Application No: M/91/21/PL
Site Address: 27 Central Drive Middleton-On-Sea PO22 7TT
Description of works: Variation of condition 2-approved plans & removal of condition 4-materials included on plans imposed under M/25/19/PL.

Thank you for your internet representation made on 29th July 2021 which has been recorded as an objection with the comments as follows:

PROJECT	27 Central Drive - Elmer Beach	DATE	16/09/18
TITLE	Proposed South Elevation	DRG NO	IBA/507/05
SCALE	1 : 50	REVISIONS	B

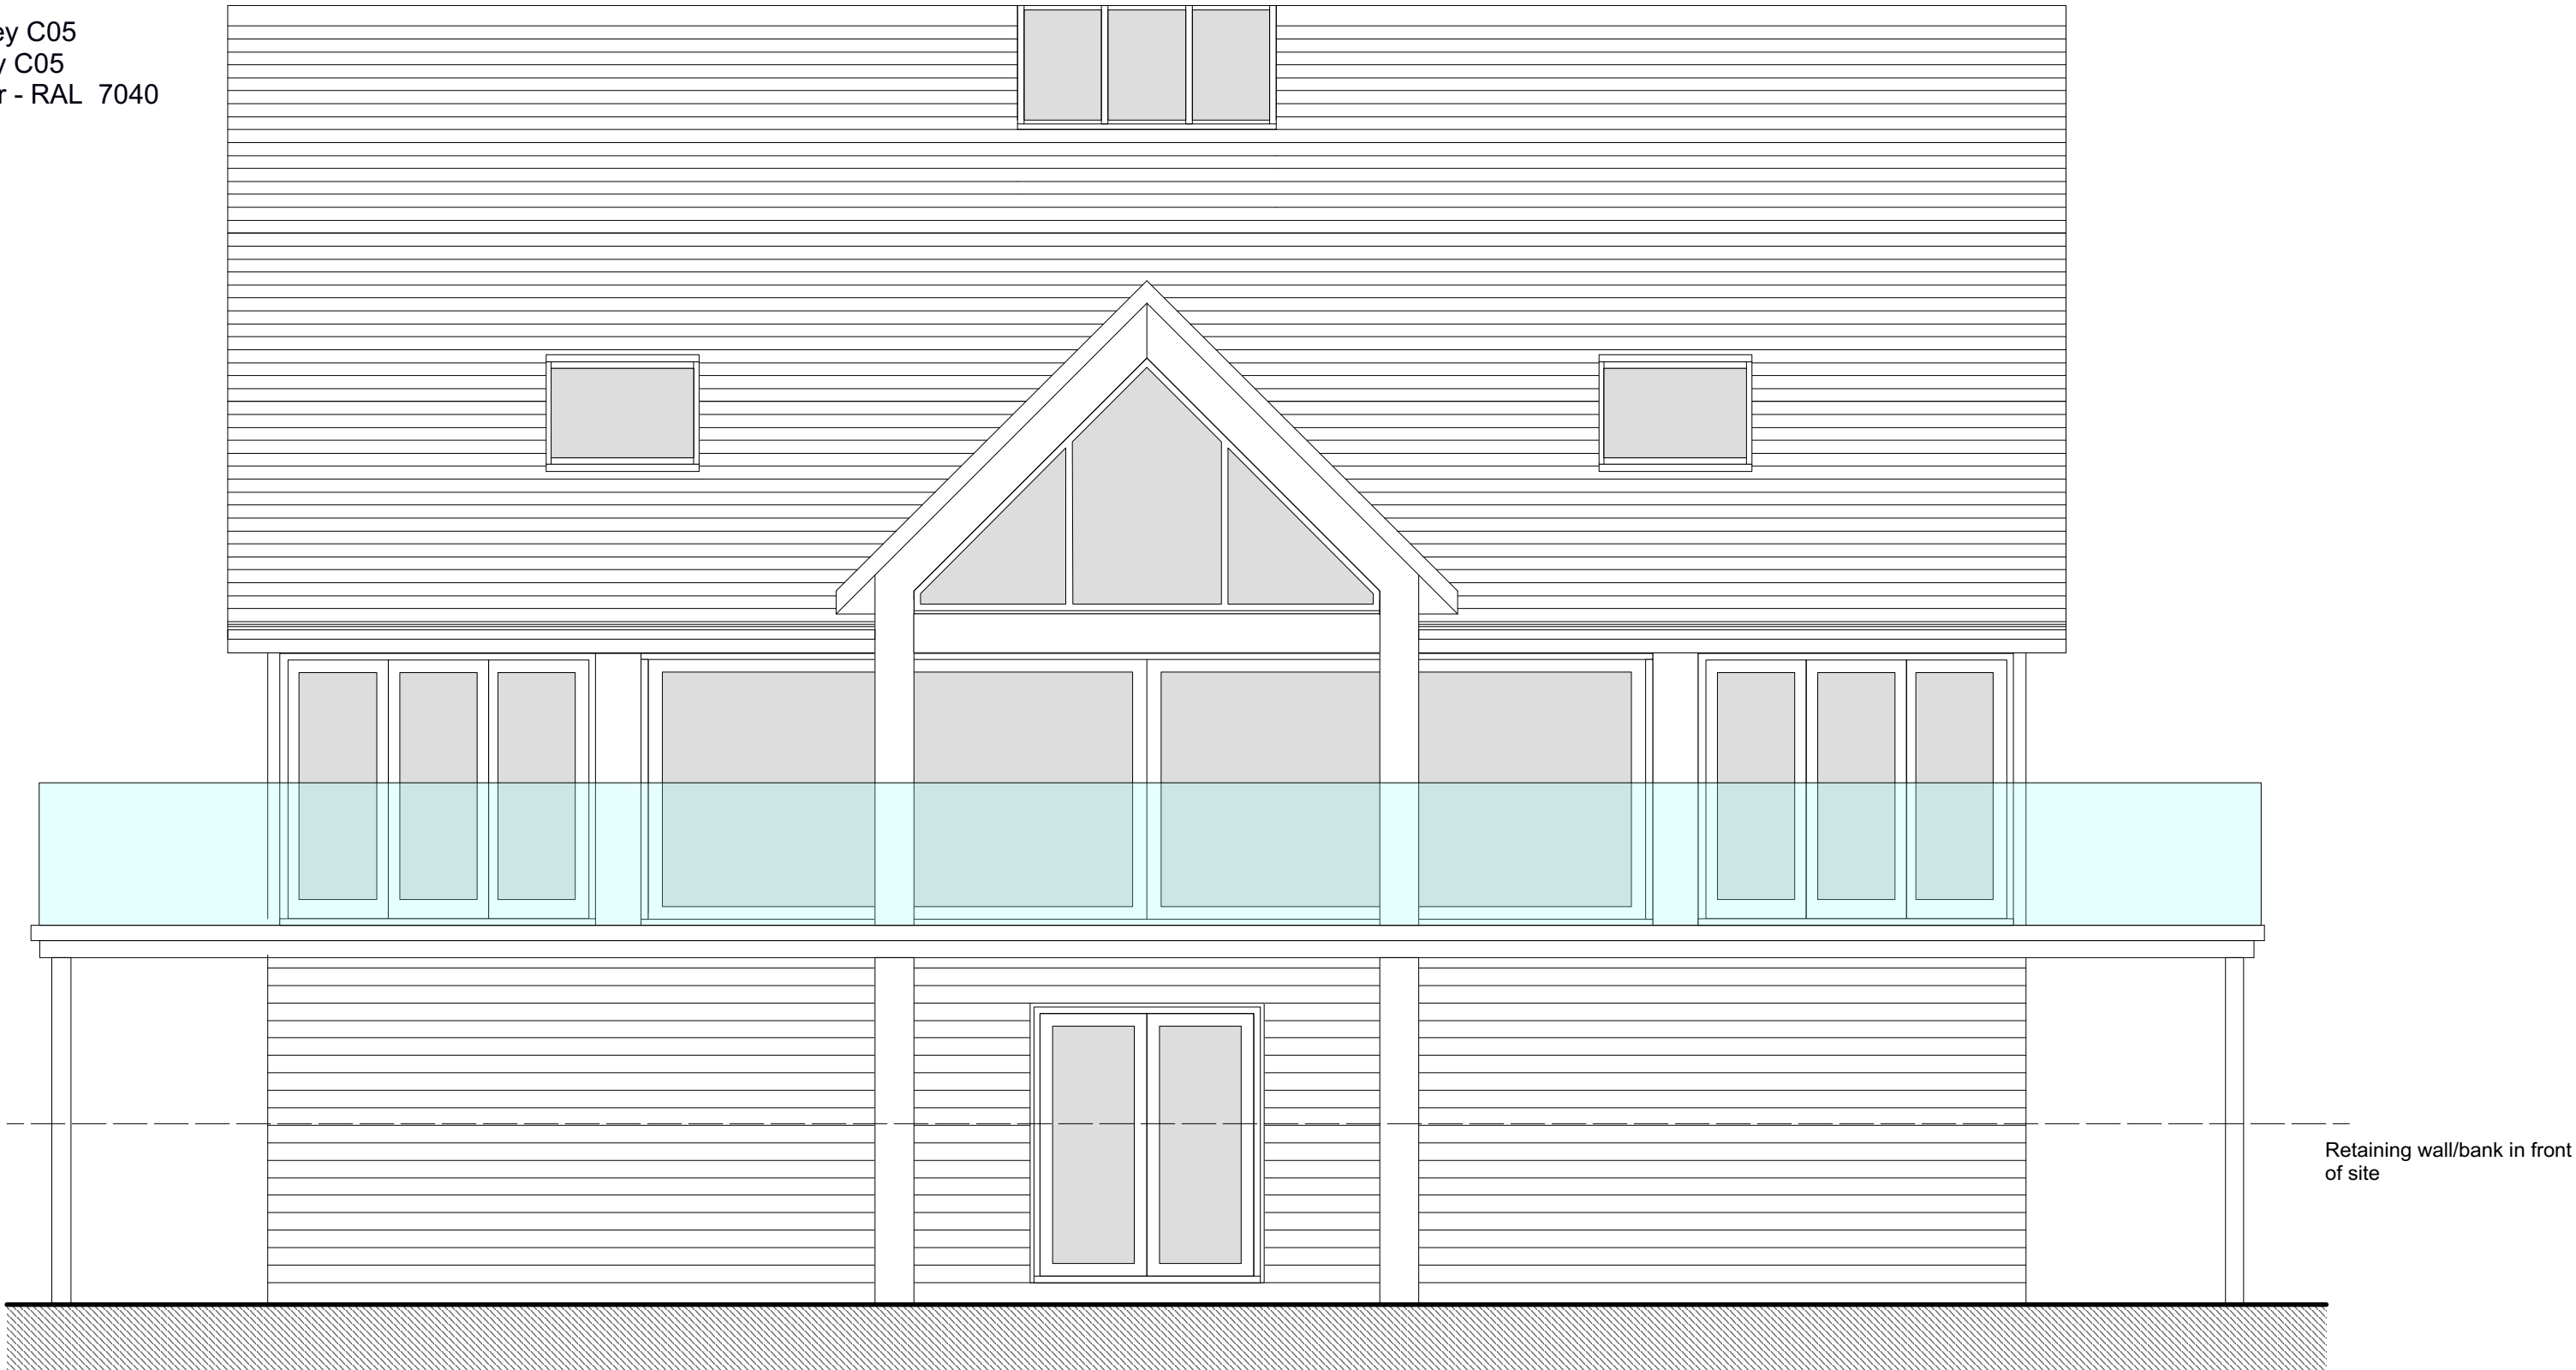
It is obvious that the height of this building is far in excess of any surrounding buildings (some 3-4 metres higher) which spoils the vista of the beach area and surrounding buildings.
The roof level of this building should be decreased in line with the surrounding buildings to provide continuity.
